Mellor Parish Council

Planning Application

3/2007/0953 77 Mellor Lane, Mellor – Proposed two storey extension, single storey extension and internal alterations...

DRAWING TITLE
Proposed Plans and Elevations

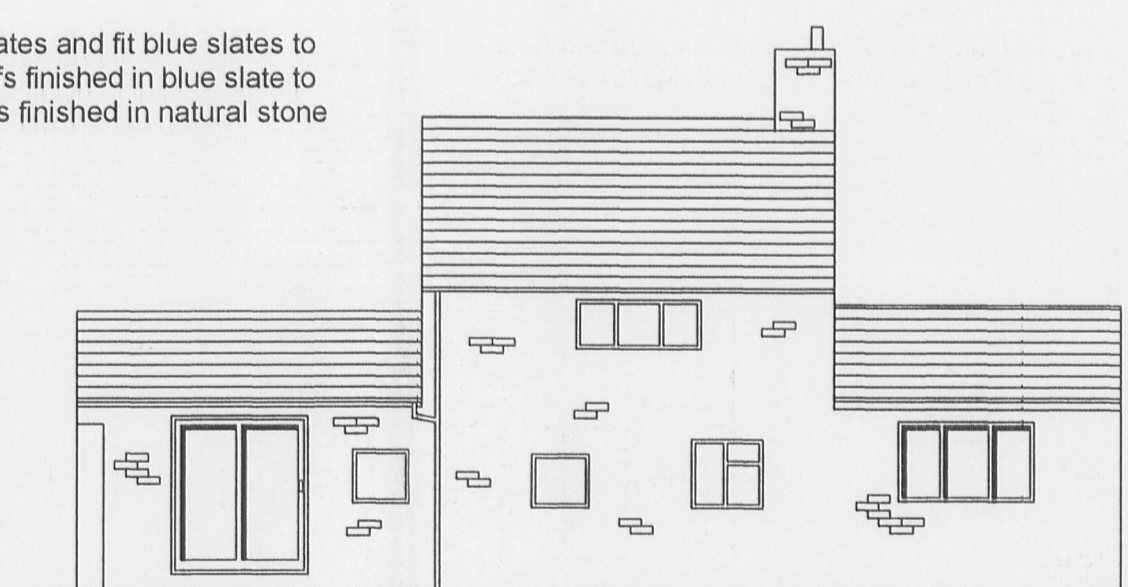
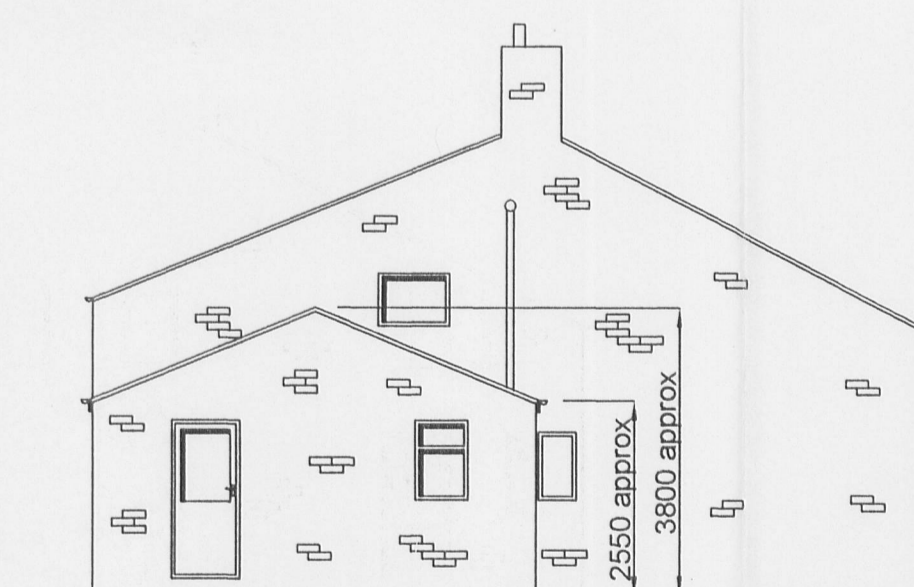
As one of the oldest properties in Mellor, the extension/restoration should be in keeping with the existing building, particularly regarding windows, doors and external framework.
